Our Ref: PEF/SD/28854
Your Ref: Y/21/18/DOC

30 April 2018

**Drainage
Land at Kings Close, Yapton**

107

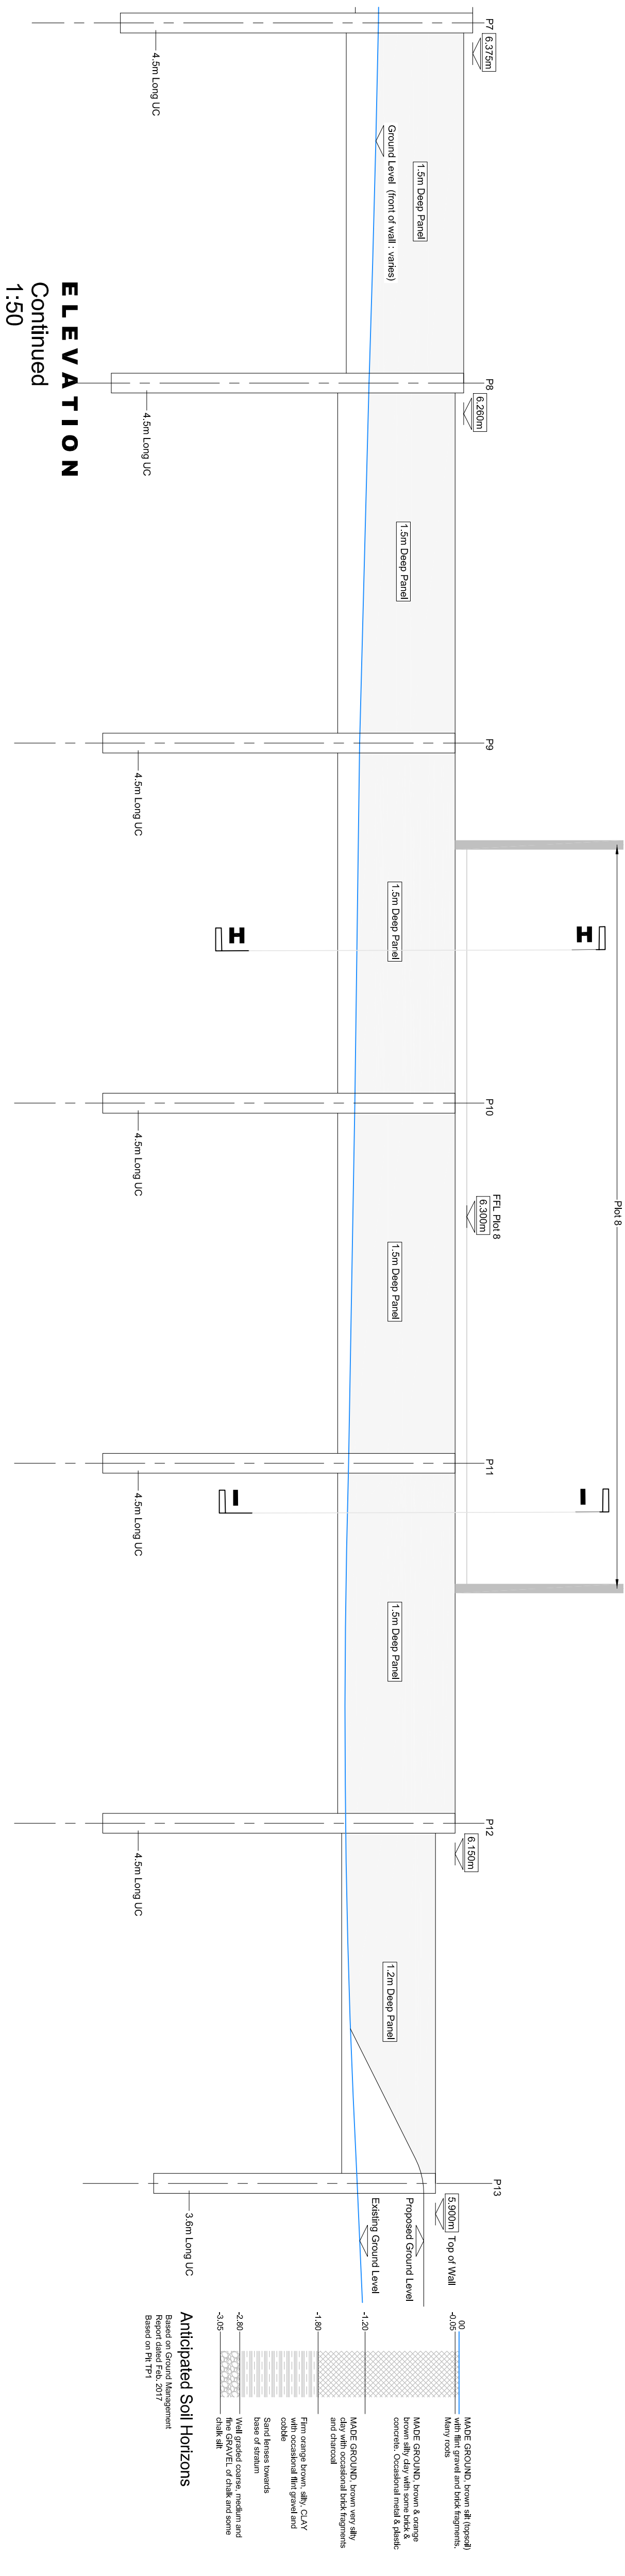
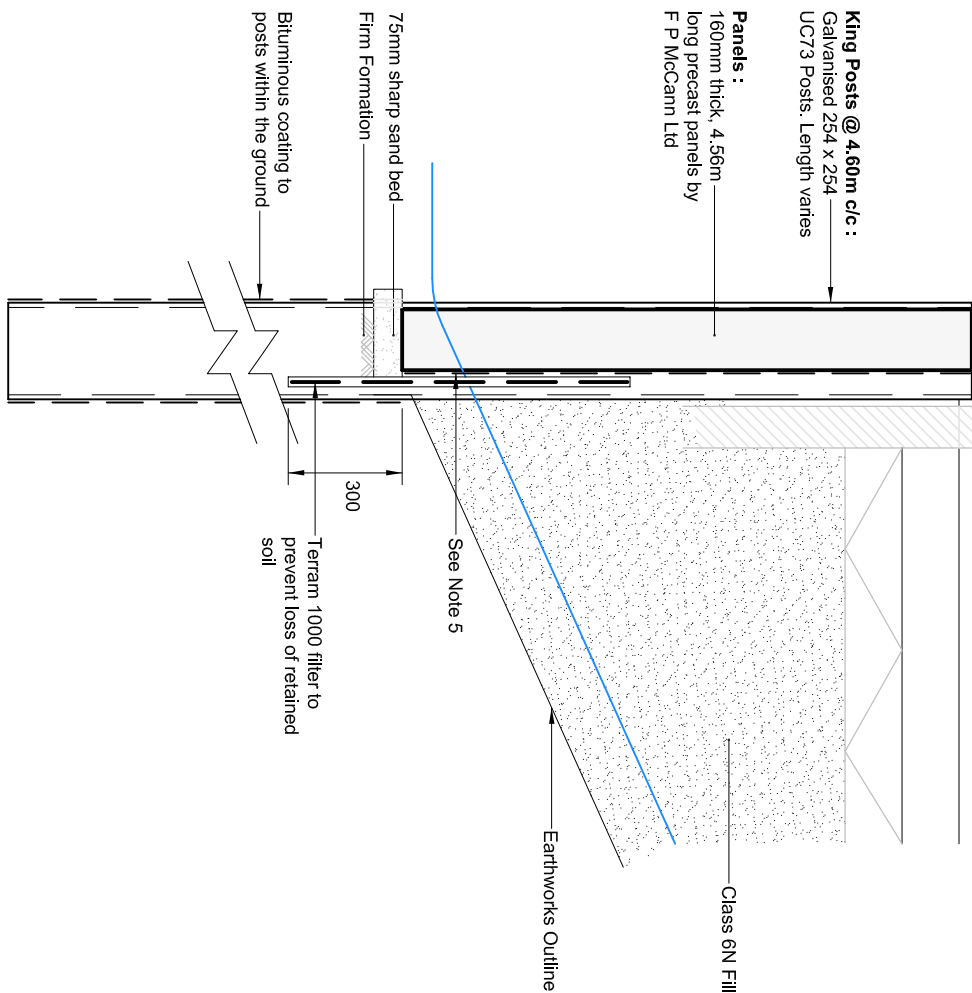
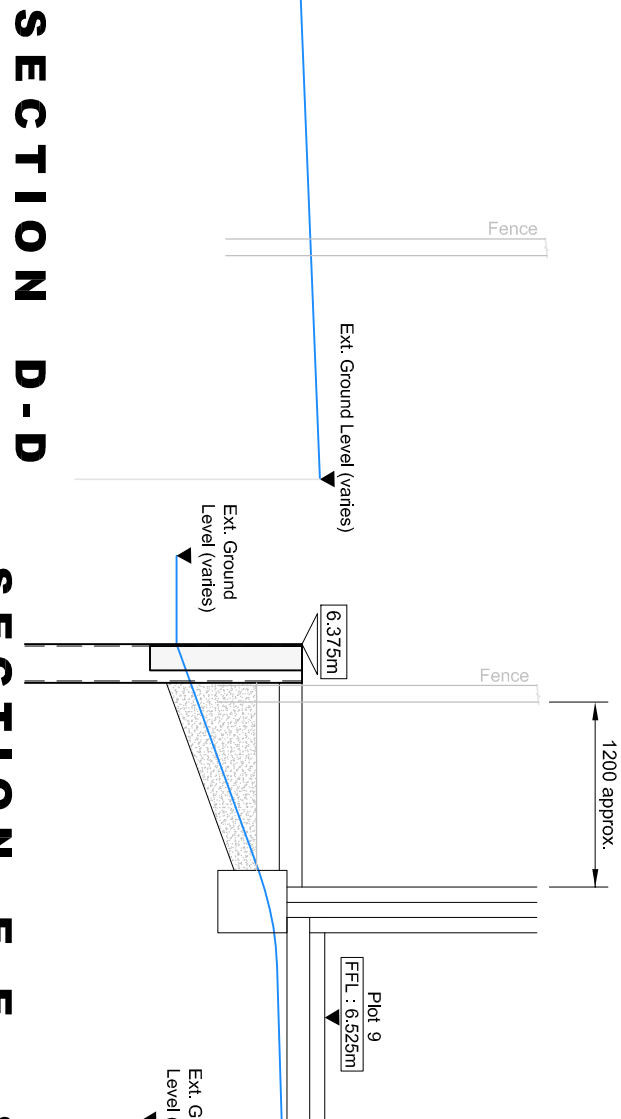
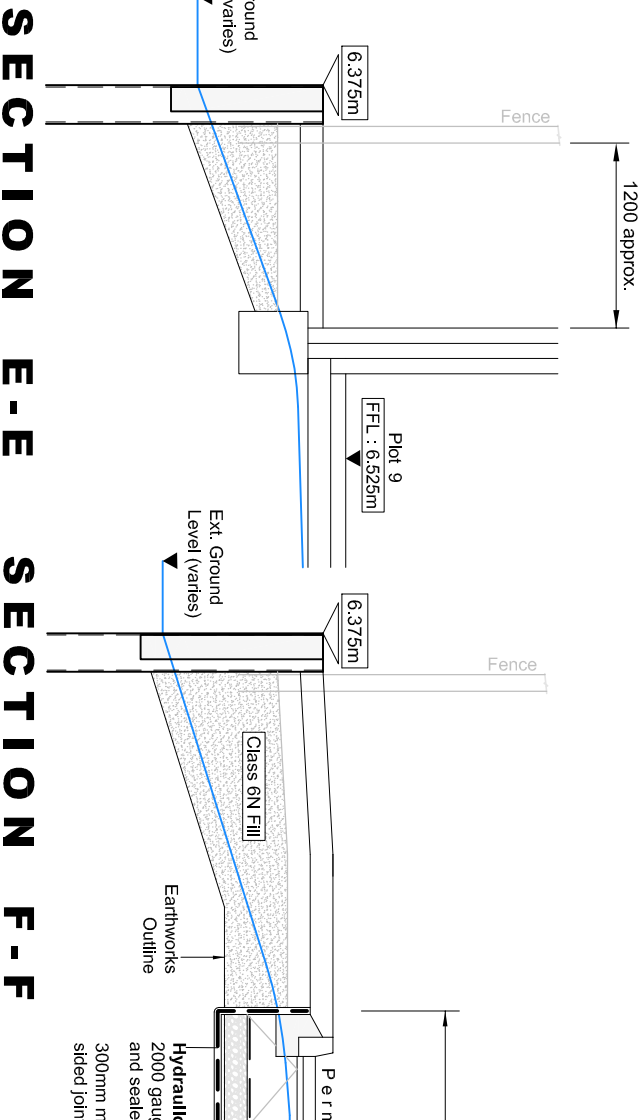
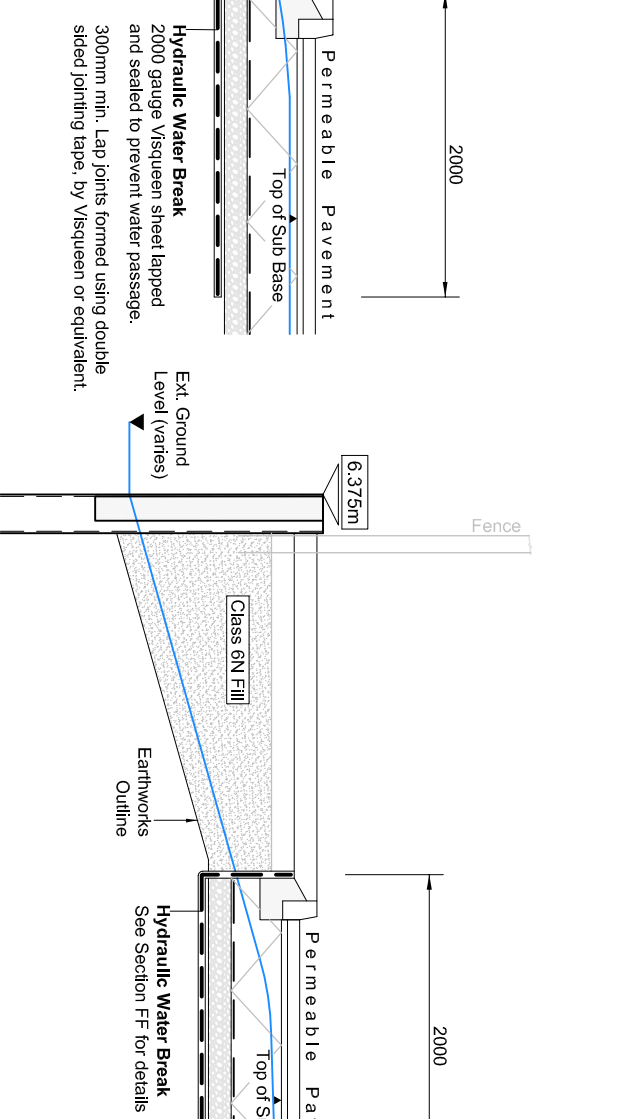
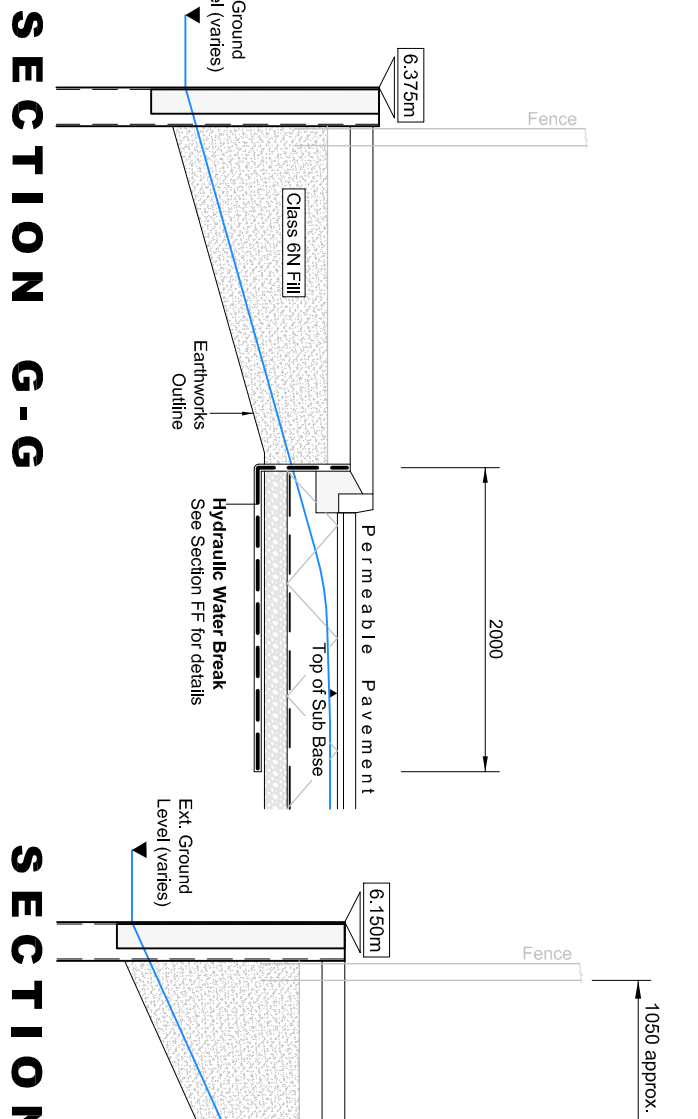
- Soakaway base and cover levels have been added to our drawing No. 28854-101.P4. Base levels represent the invert level of the storage void former.
- Step rungs have been added to our drawing No. STD.01.47A. Manholes Type P2 have not had step rungs detailed to accord with adopted manhole details.
- The depth of the concrete bed at the base of the catchpits has been increased to 225mm.
- Manhole cover types and grades are shown on the schedules and standard drawings. Cover grades A15, B125, C250 and D400 imply compliance with BS EN124.
- Our marked-up drawing shows flood exceedance flow routes.
- Drawings 106.P2 and 107.P1 show sections through the proposed king post retaining wall.
